Phone: 0300 123 6780
Email: Kathryn.Walsh@lancashire.gov.uk
Your ref: 3/2024/0213
Our ref: 3/2024/0213/HDC/KW
Date: 12 March 2026

Location: Eight at Gazegill Gazegill Organics Dancer Lane Rimington BB7 4EE
Proposal: Retrospective planning application to continue use of single storey restaurant building, outdoor seating area, play area and vehicle parking area.
Grid Ref: 382097 446306

Lancashire County Council acting as the Local Highway Authority (LHA) does not consider that the application as submitted fully assesses the highway impact of the proposed development and further information is required as set out in this response.

Drawing; Site Plans

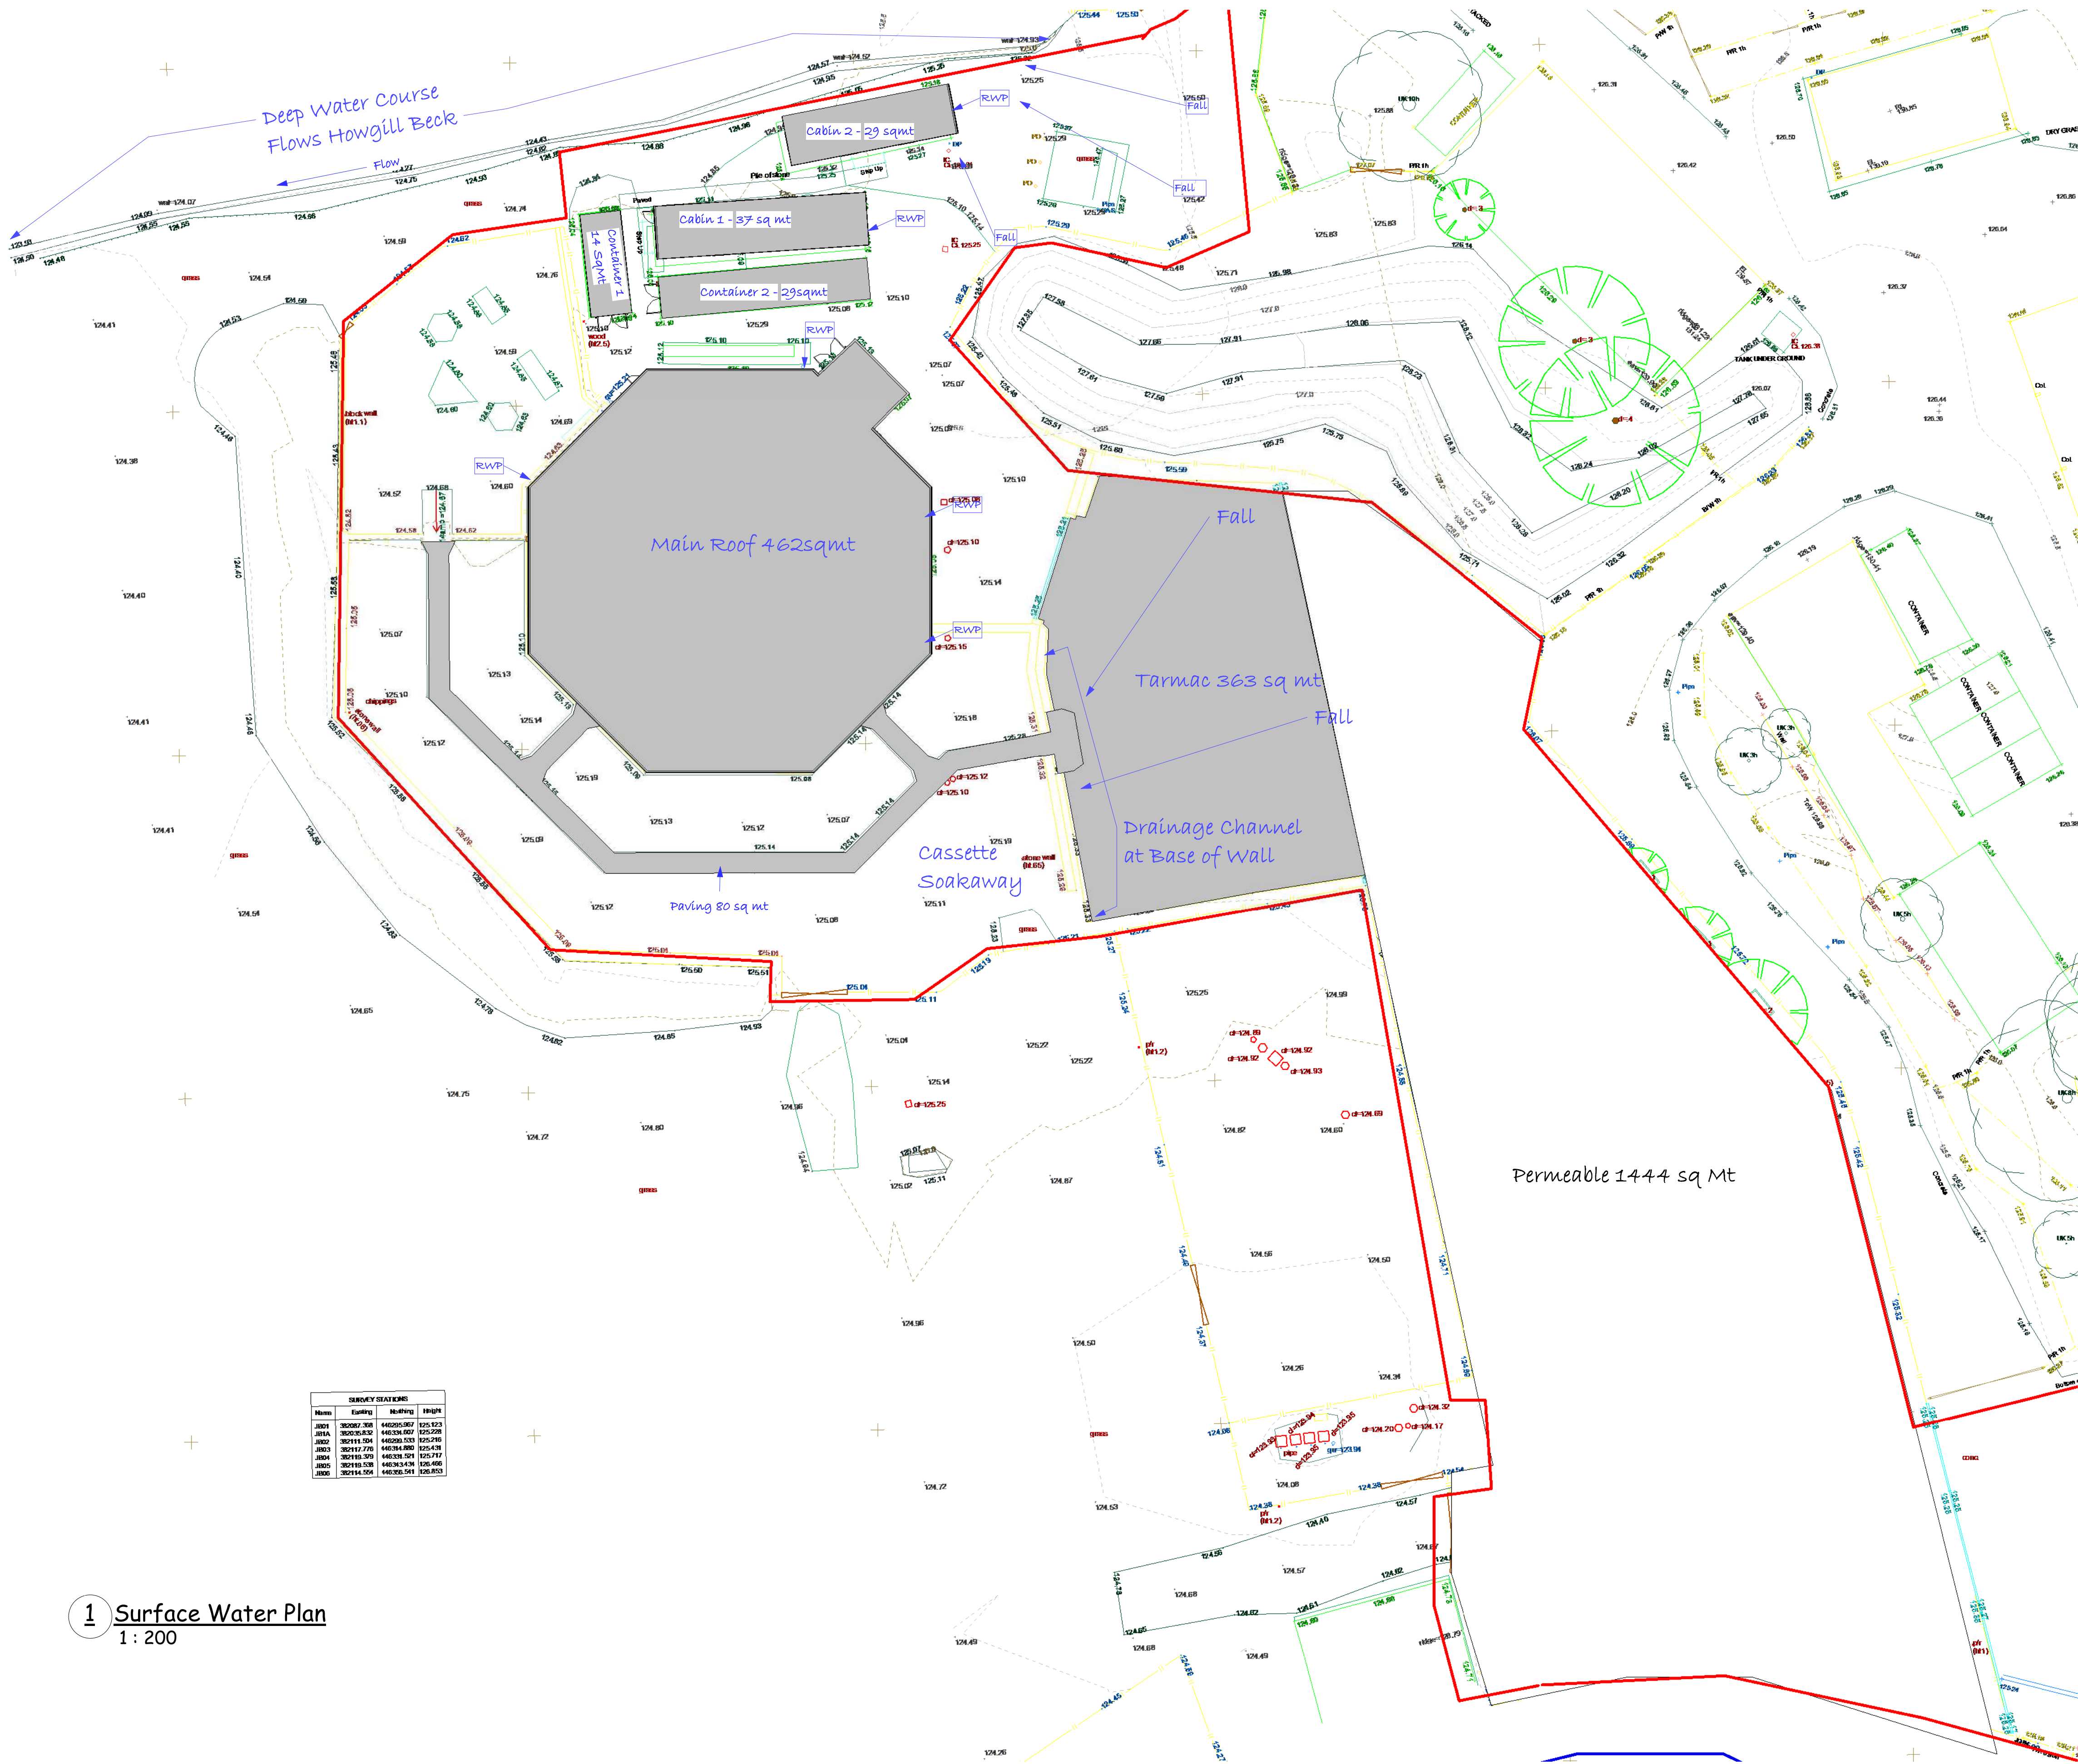
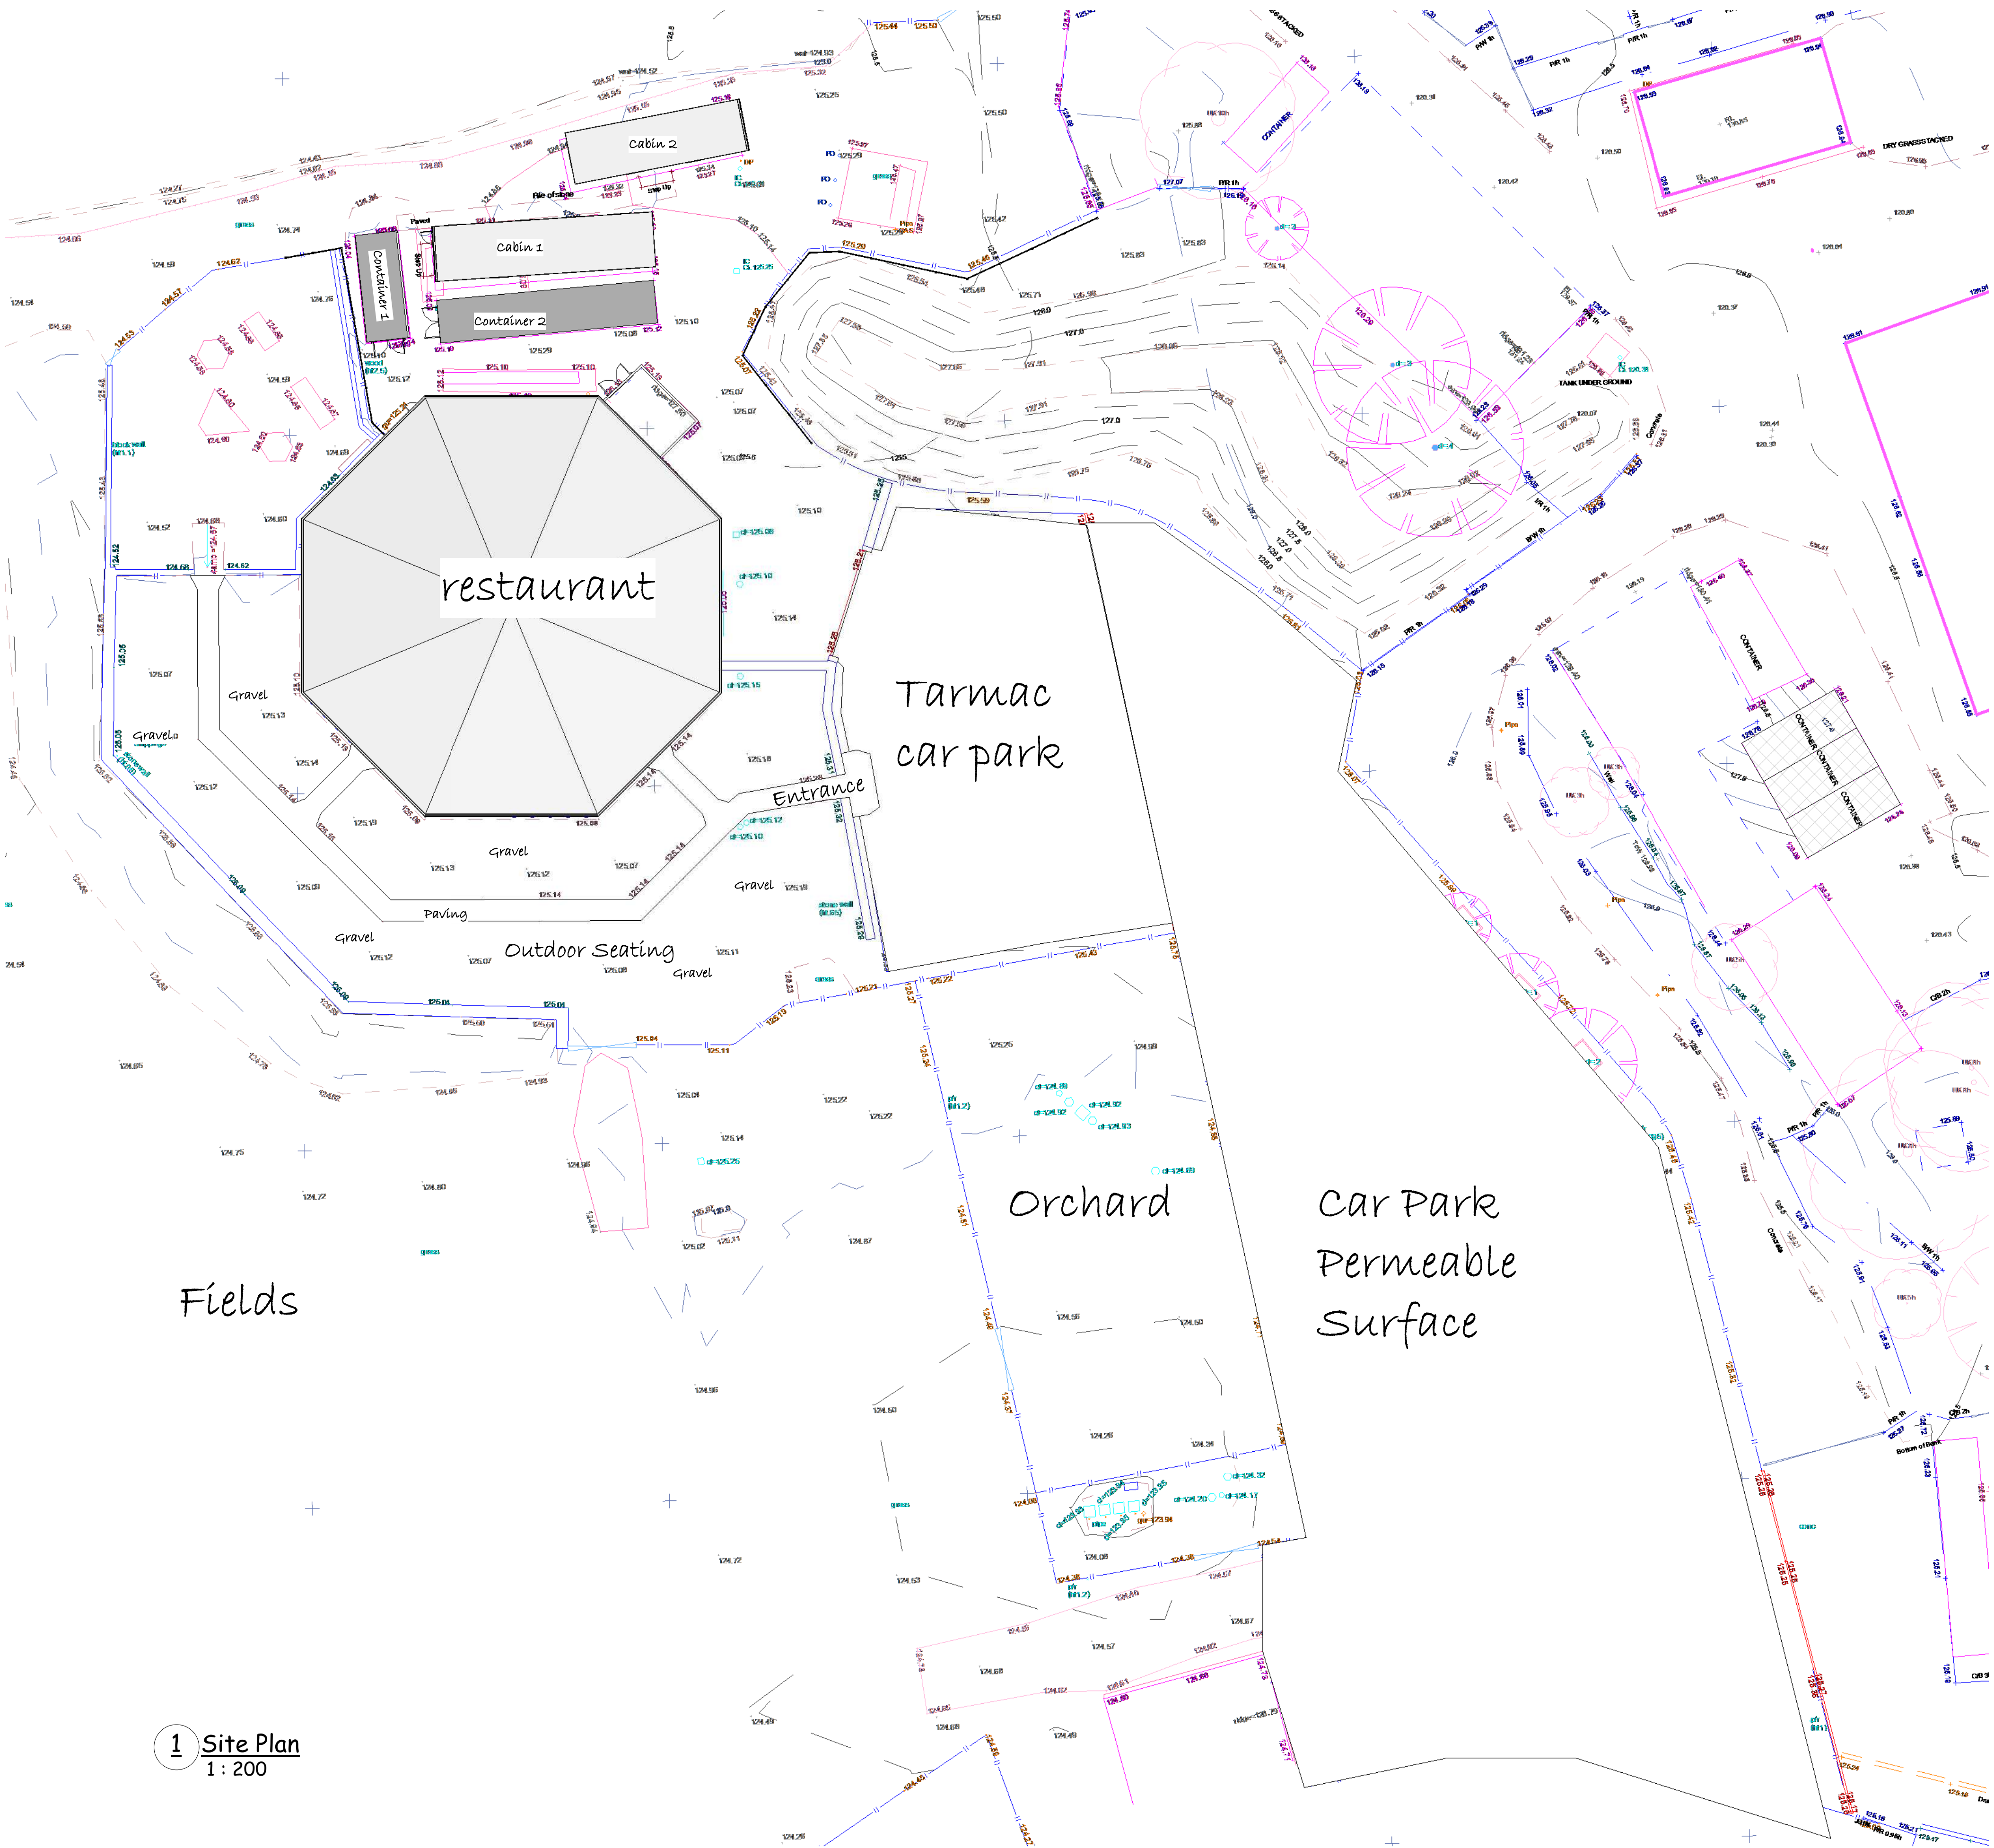
The application details access improvements, however, a detailed dimensional plan showing the existing site access and the proposed site access has not been included within the application. The supported highway technical note details a number of access improvement such as the verge vegetation clearance to improve visibility and accommodate vehicle passing at the entrance to Gazegill Farm.

The LHA request that detailed dimensional site access plan is provided so that a clear comparison can be made of the suggested improvements. Given the commercial nature of the site, it is expected that the access is at least 6m wide.

The parking provision proposed in the Highways Technical Note show the servicing arrangements are clearly demonstrated and raise no operational concerns, the applicant has failed to assess combined parking demand from both the restaurant and the Gazegill Organics Farm Shop, despite explicitly stating that the car park will serve both uses. There are 45 standard spaces within the site which exceed the maximum standard of 39 spaces as required under the Joint Lancashire Structure Plan for a 310 sqm restaurant. Whilst this does not include the outdoor seating area, the applicant has advised that the restaurant can cater for 50 covers, which has been taken into account. This leaves 6 spaces available for use by those who attend the Farm Shop yet no survey of existing

- A detailed, scaled site access plan, including dimensions and any proposed widening.
- Clear identification of passing places within the applicant's control with evidence that these can be secured, maintained, and conditioned long-term. To confirm which areas of Dancer Lane and proposed passing places fall within the applicant's ownership or influence.
- Drawings demonstrating available visibility along Dancer Lane, at each passing point.

- A more robust traffic generation methodology, accounting for multiple vehicles per booking, staff trips and overlapping with farm shop traffic as well as consideration for seasonal variation.
- A combined assessment of parking survey for both the restaurant and the farm shop.
